Application No: P/76/21/HH
Site Address: 10 Dukes Meadow Pagham PO21 3PJ
Description of works: Removal of existing conservatory and erection of a rear single storey extension, single storey side extension, single storey front extension and loft conversion to form new first floor with front and rear dormer projection.

Thank you for your internet representation made on 19th June 2021 which has been recorded as an objection with the comments as follows:

sheet 1 of 3

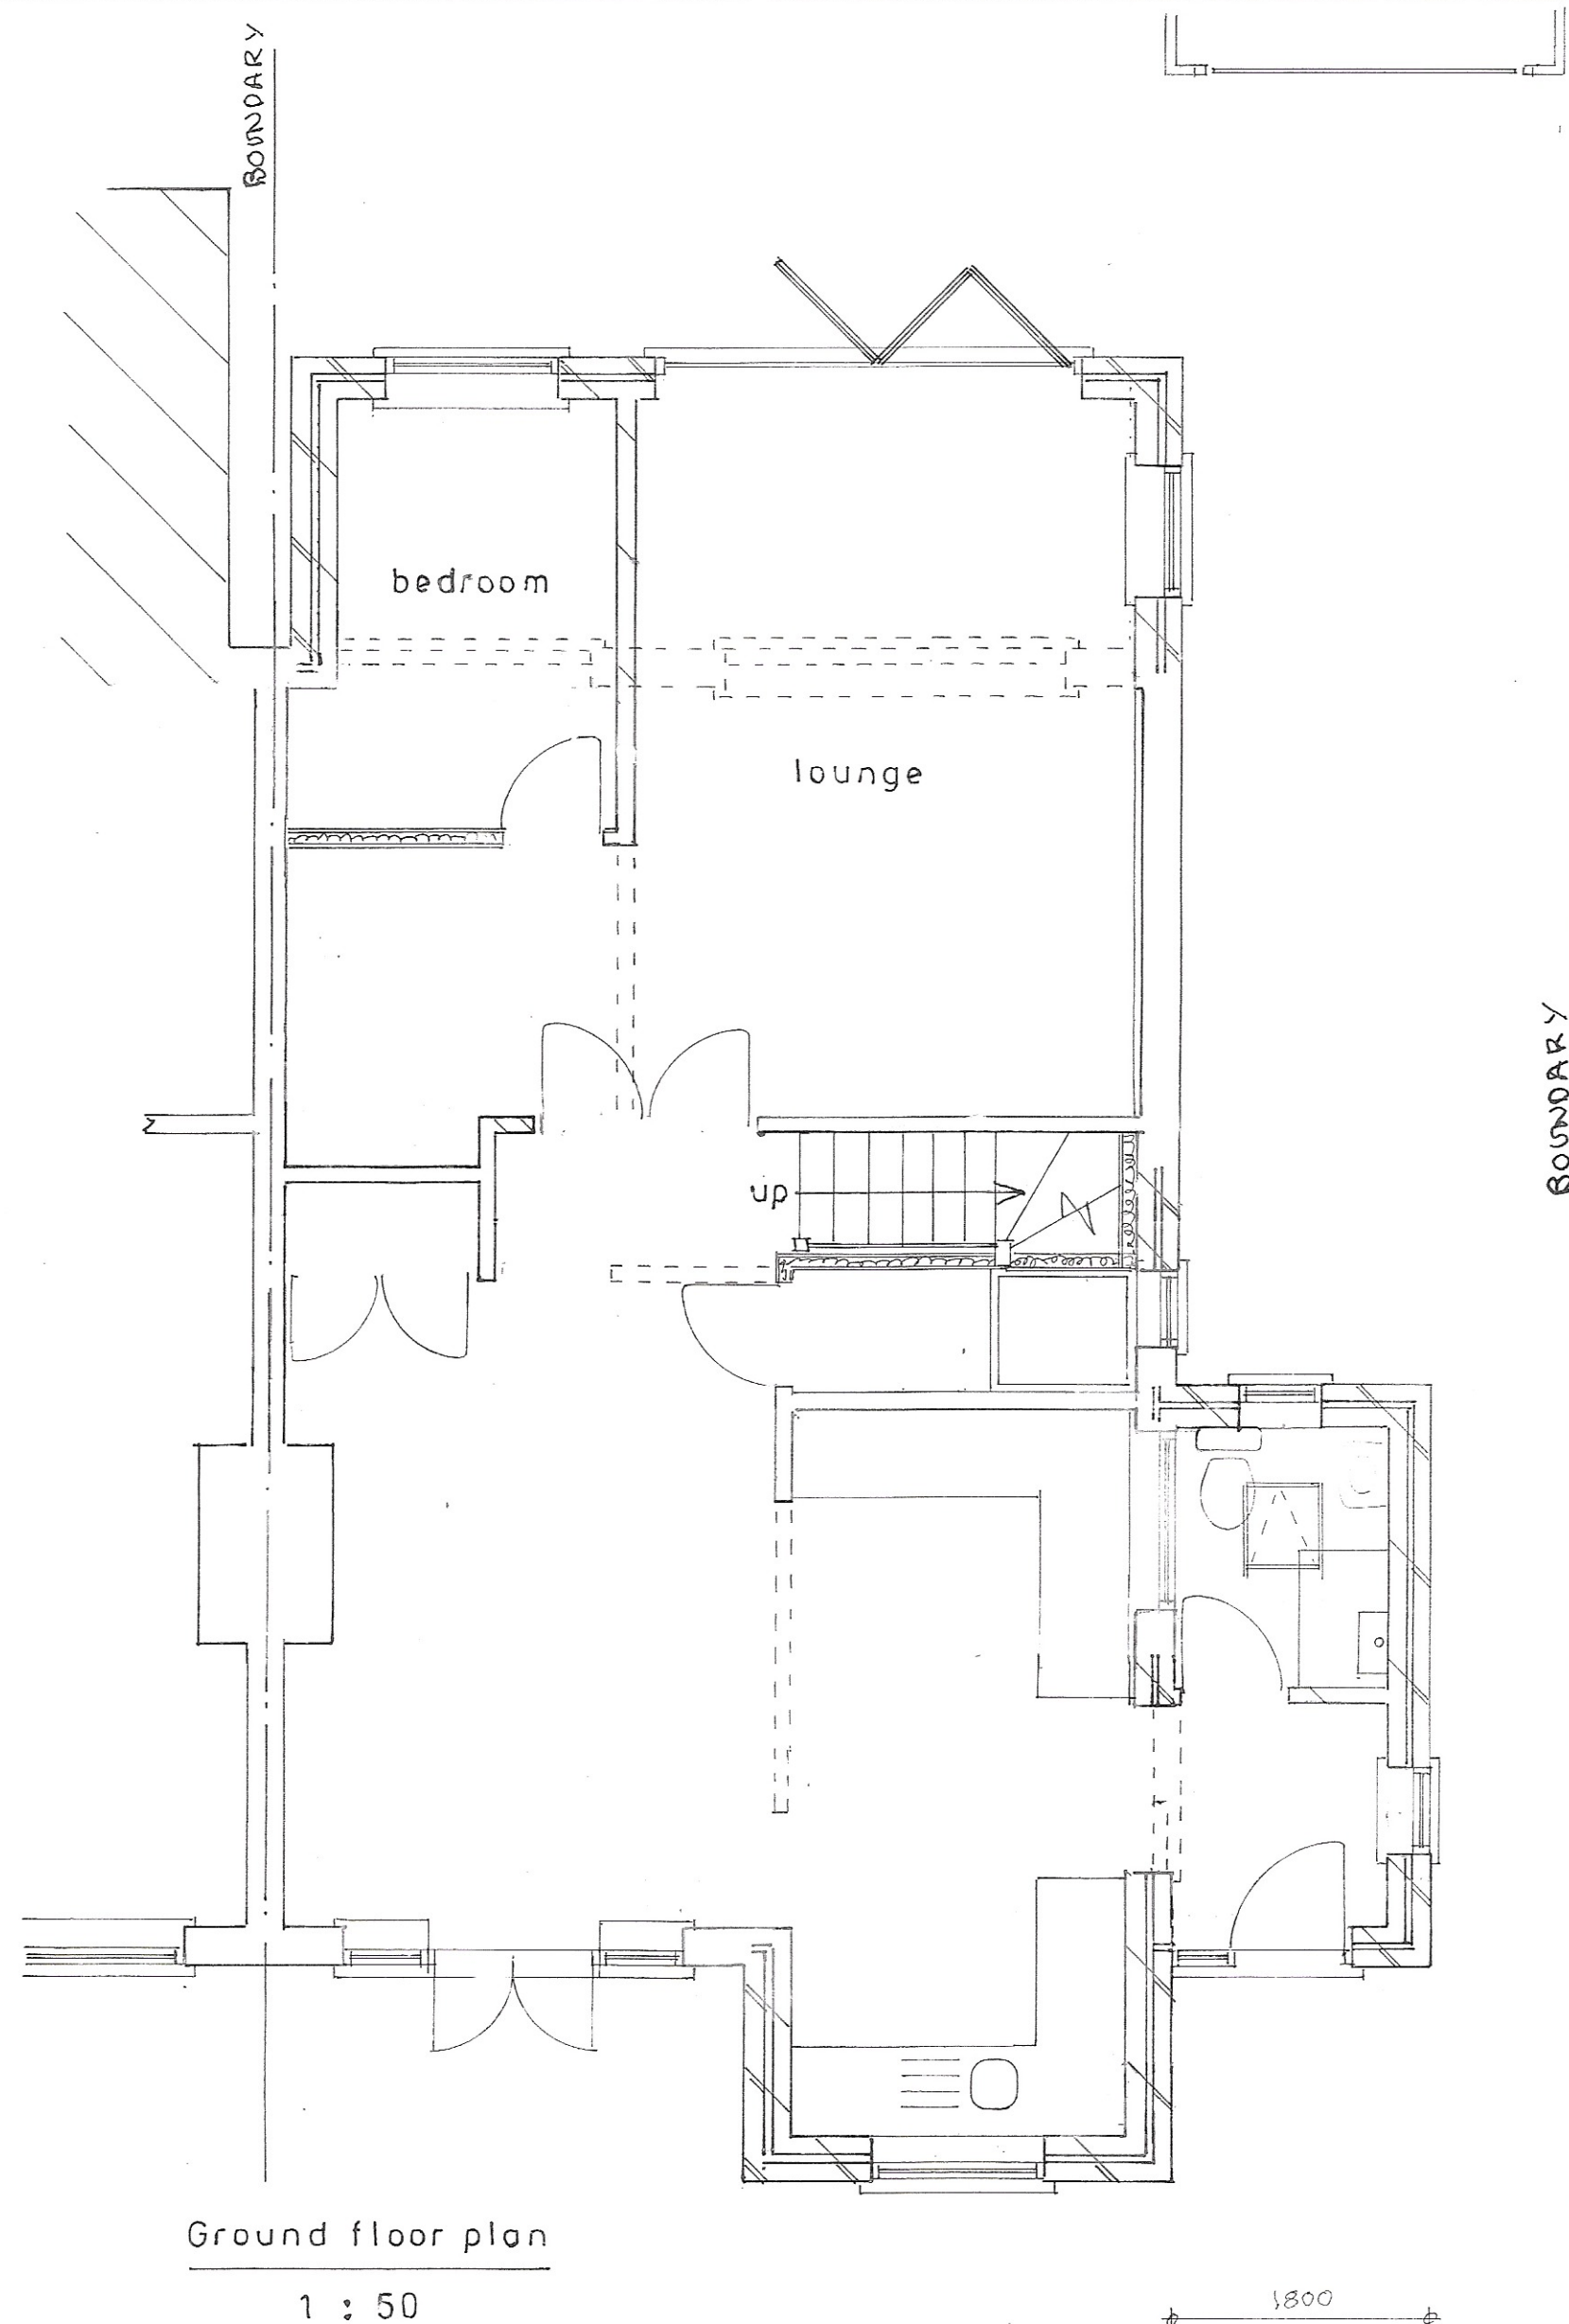
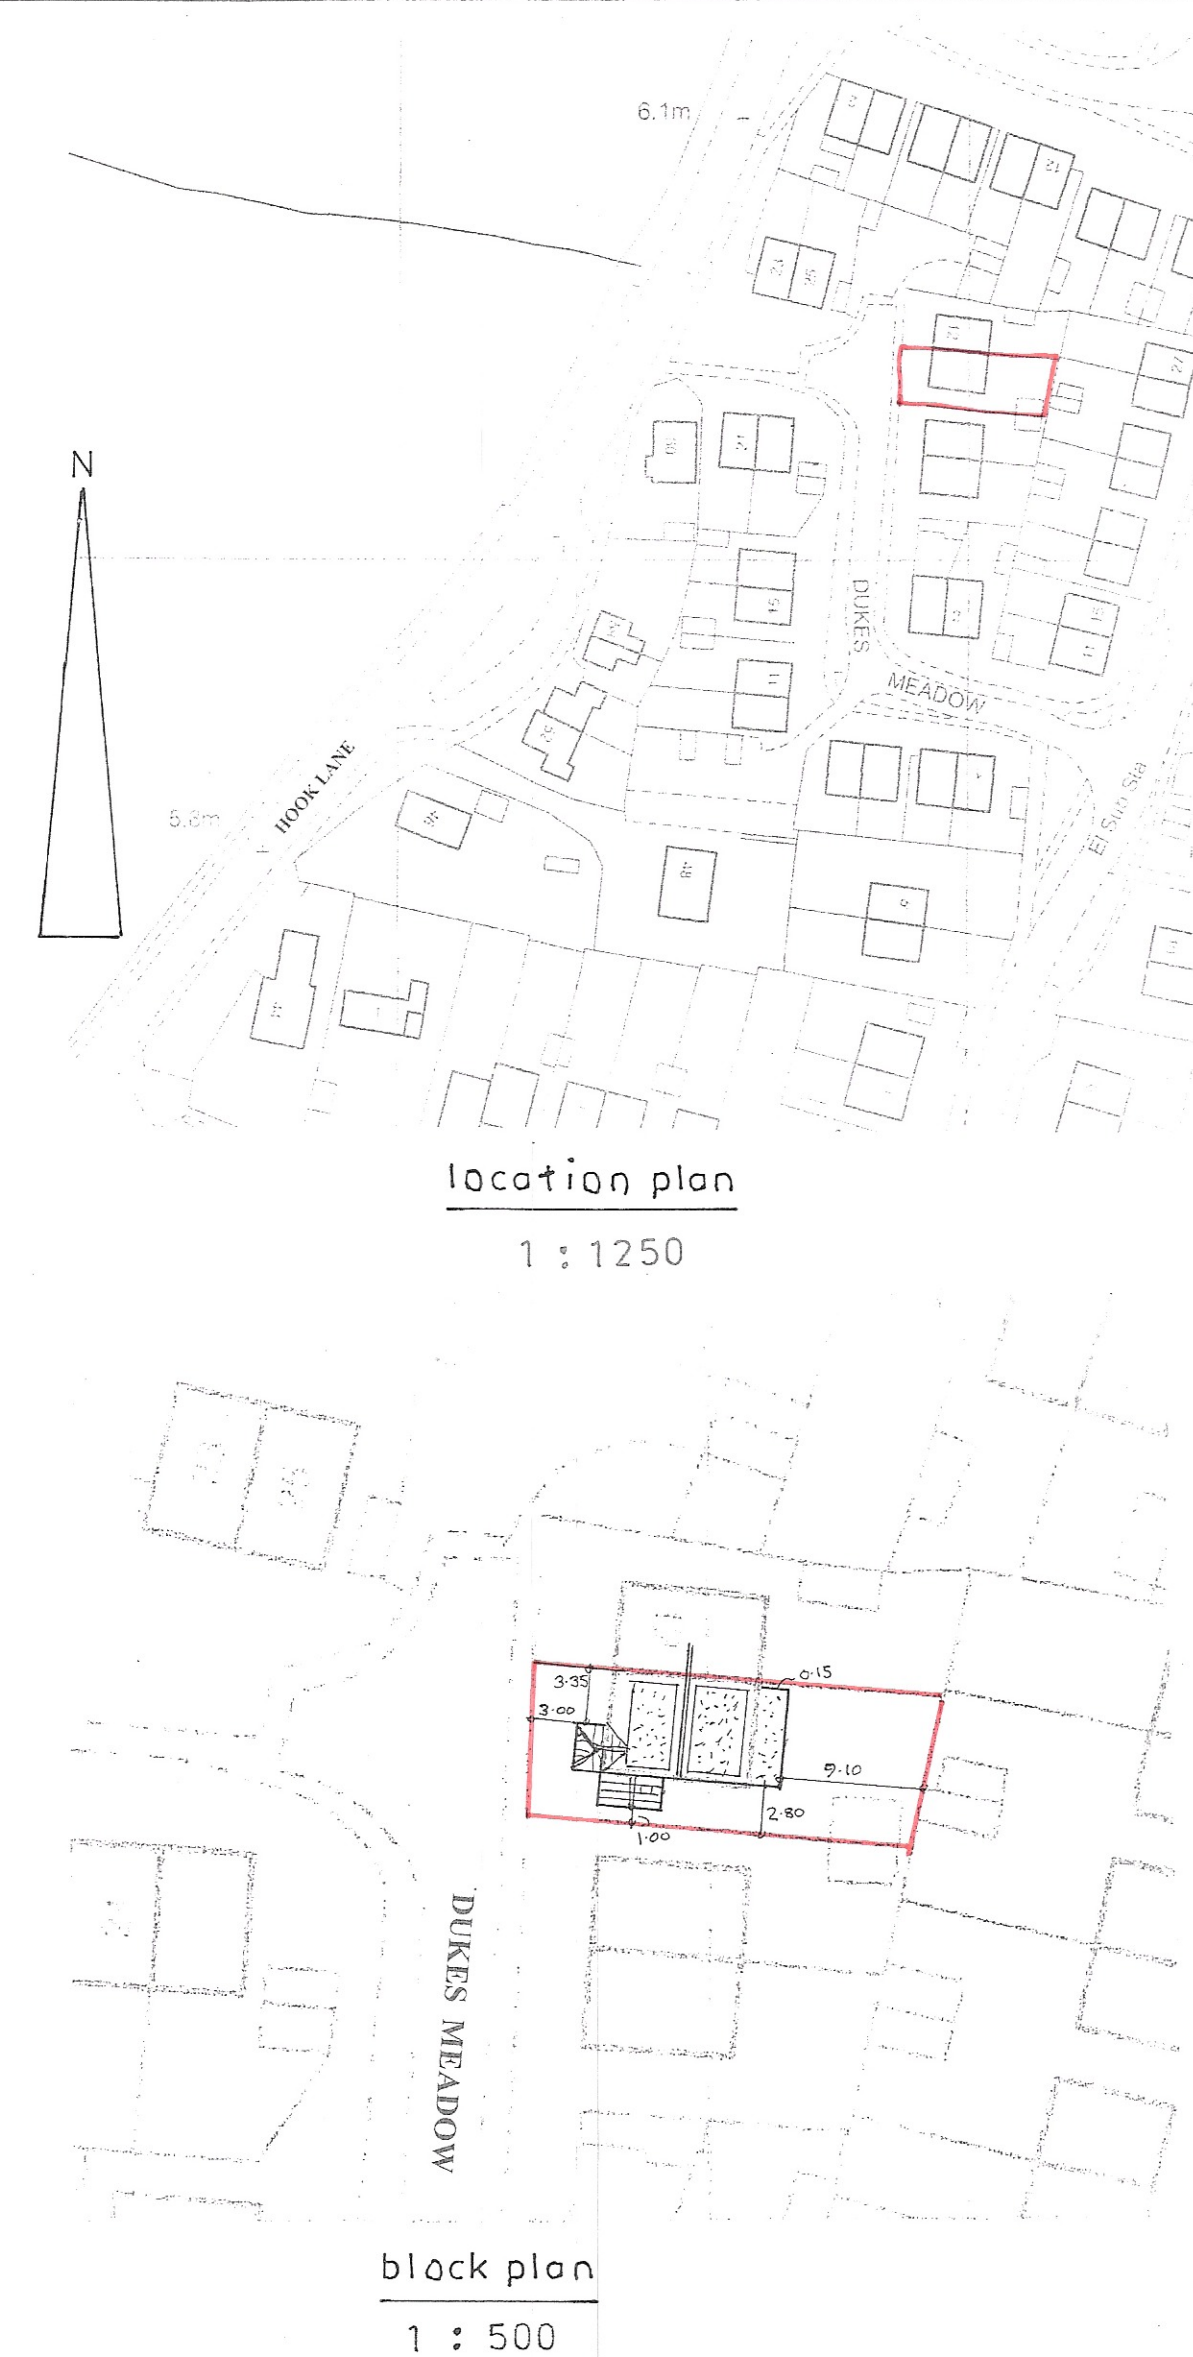
The application for a front and rear dormer projection is not in accordance with previous applications that have been allowed in dukes meadow and is totally out of character with the area. The proposed plans for the single storey front extension goes beyond the original building line. The proposed plans also show 'patio doors' to the front of the property which is totally out of keeping for the area. It looks as if RSJ's may be needed which could mean that a 'party wall agreement' may be required. As my Sky dish is fixed to the chimney I wonder whether it will affect my satellite signal.
